Charlotte Department of Transportation

Memorandum

Date: January 25, 2008

Subject: Rezoning Petition 08-033: Located on the west side of Park Road
between Heather Lane and Drexel Place
(revised 11/14/07)

**PRELIMINARY
SITE PLAN**

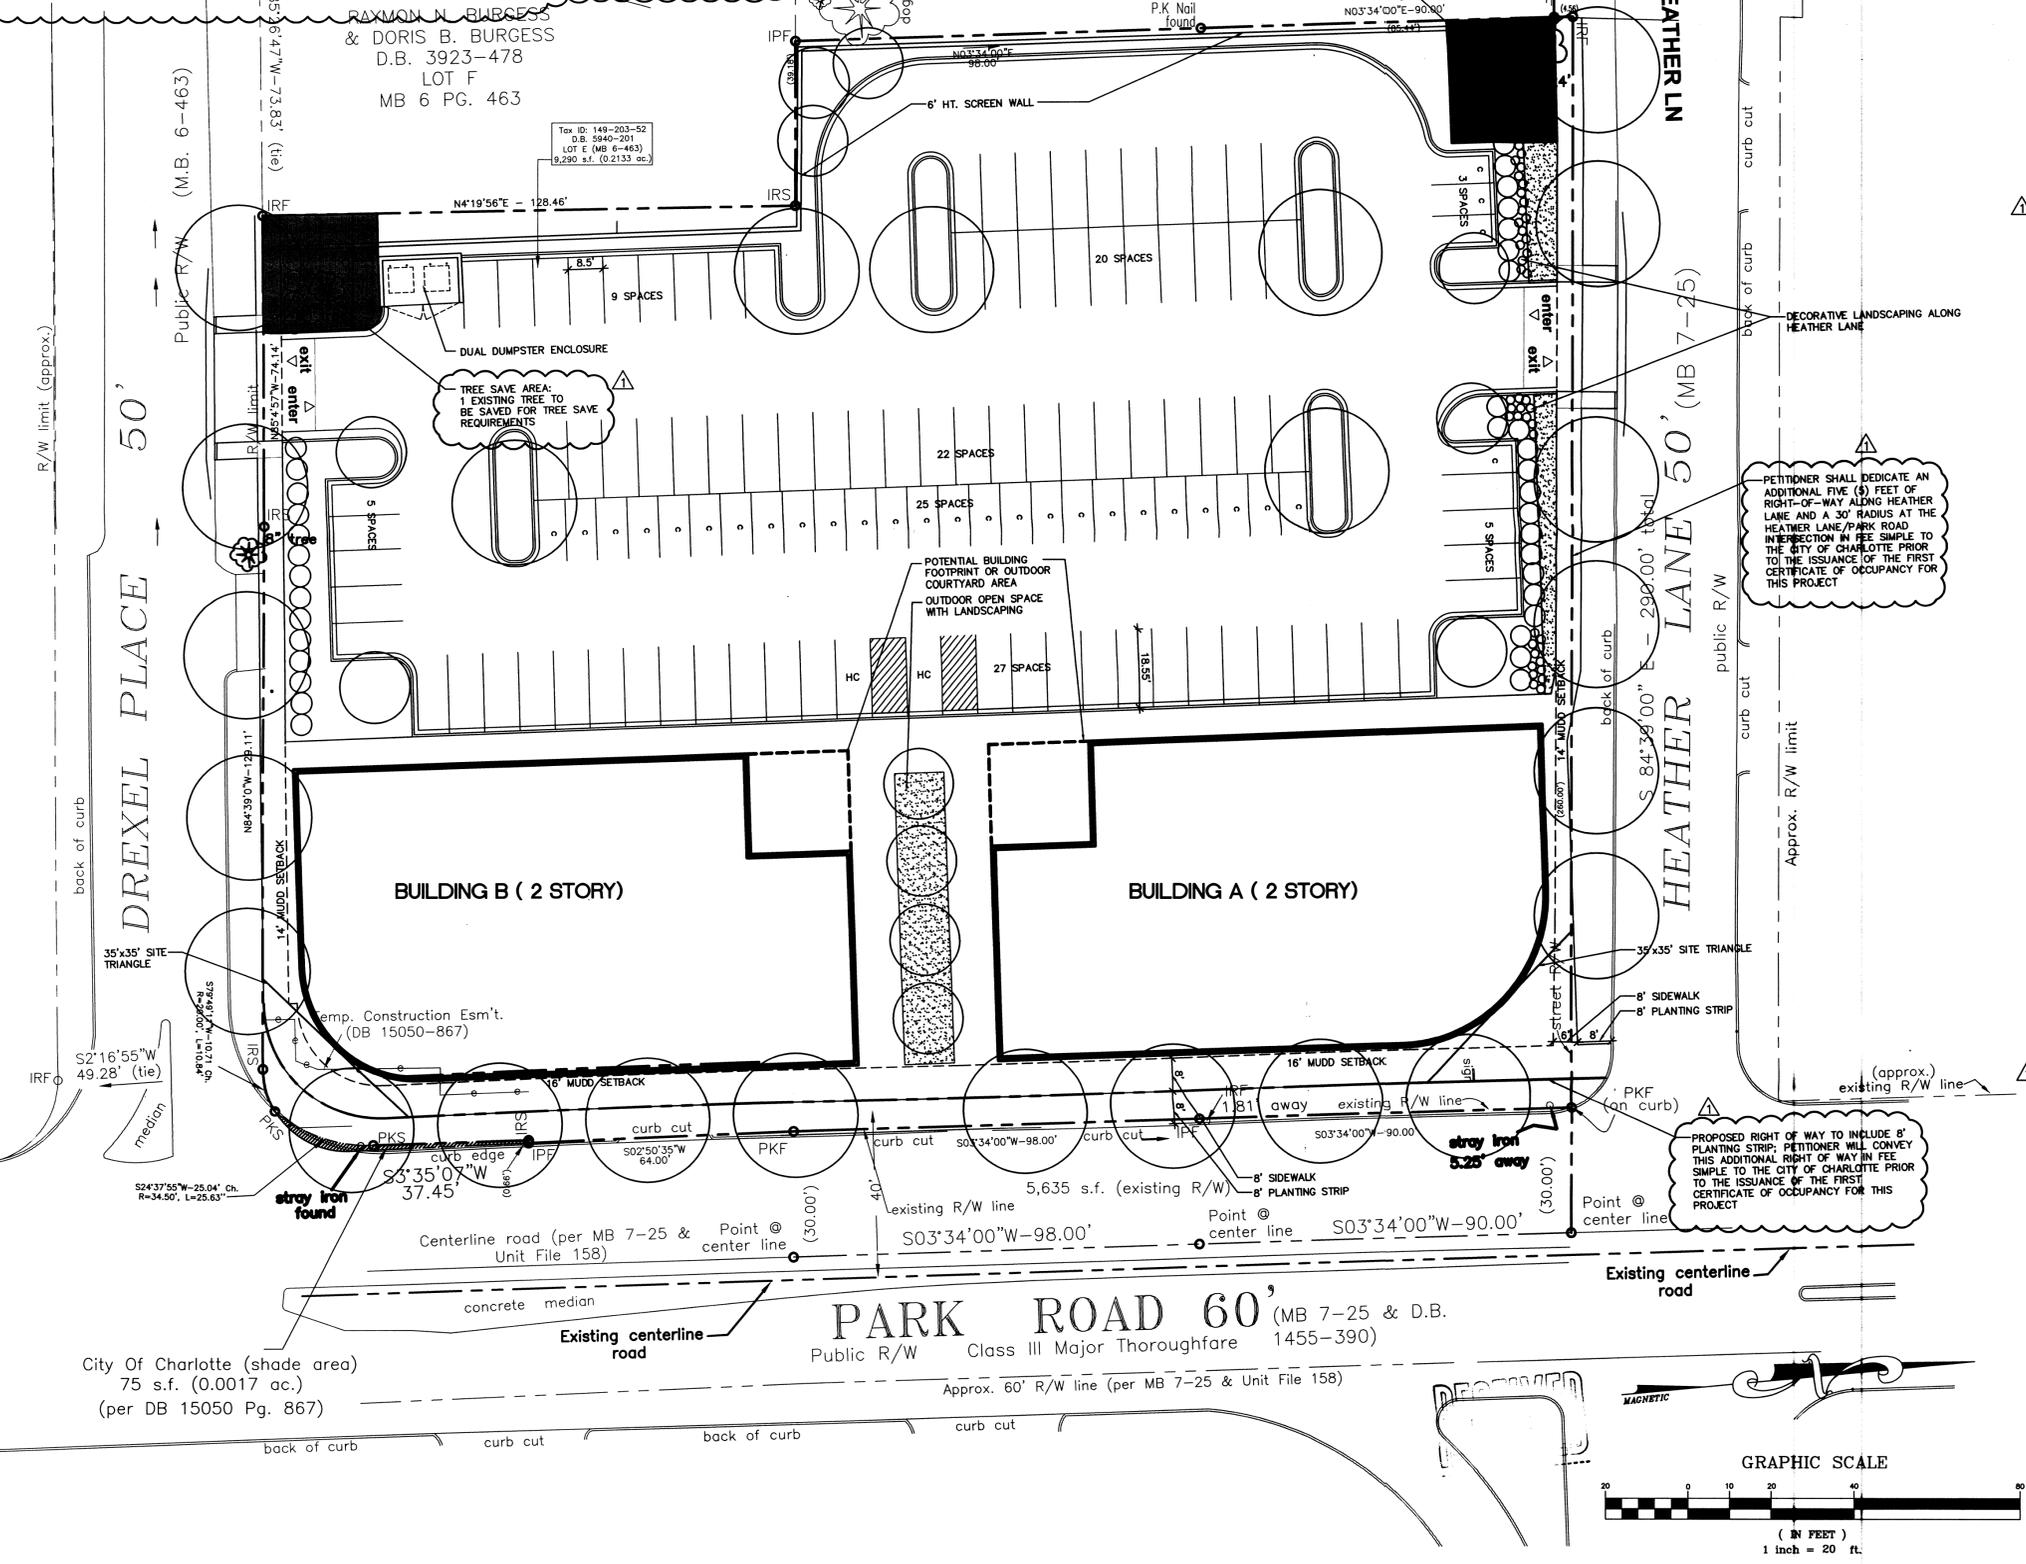
1. The driveways to the site are required to be Type II-Modified (ramp type with radii) that provide for the sidewalk grade to be maintained through the driveway. This driveway type should be noted on the site plan to aid the designer in the preparation/submittal of plans for subsequent permitting processes.
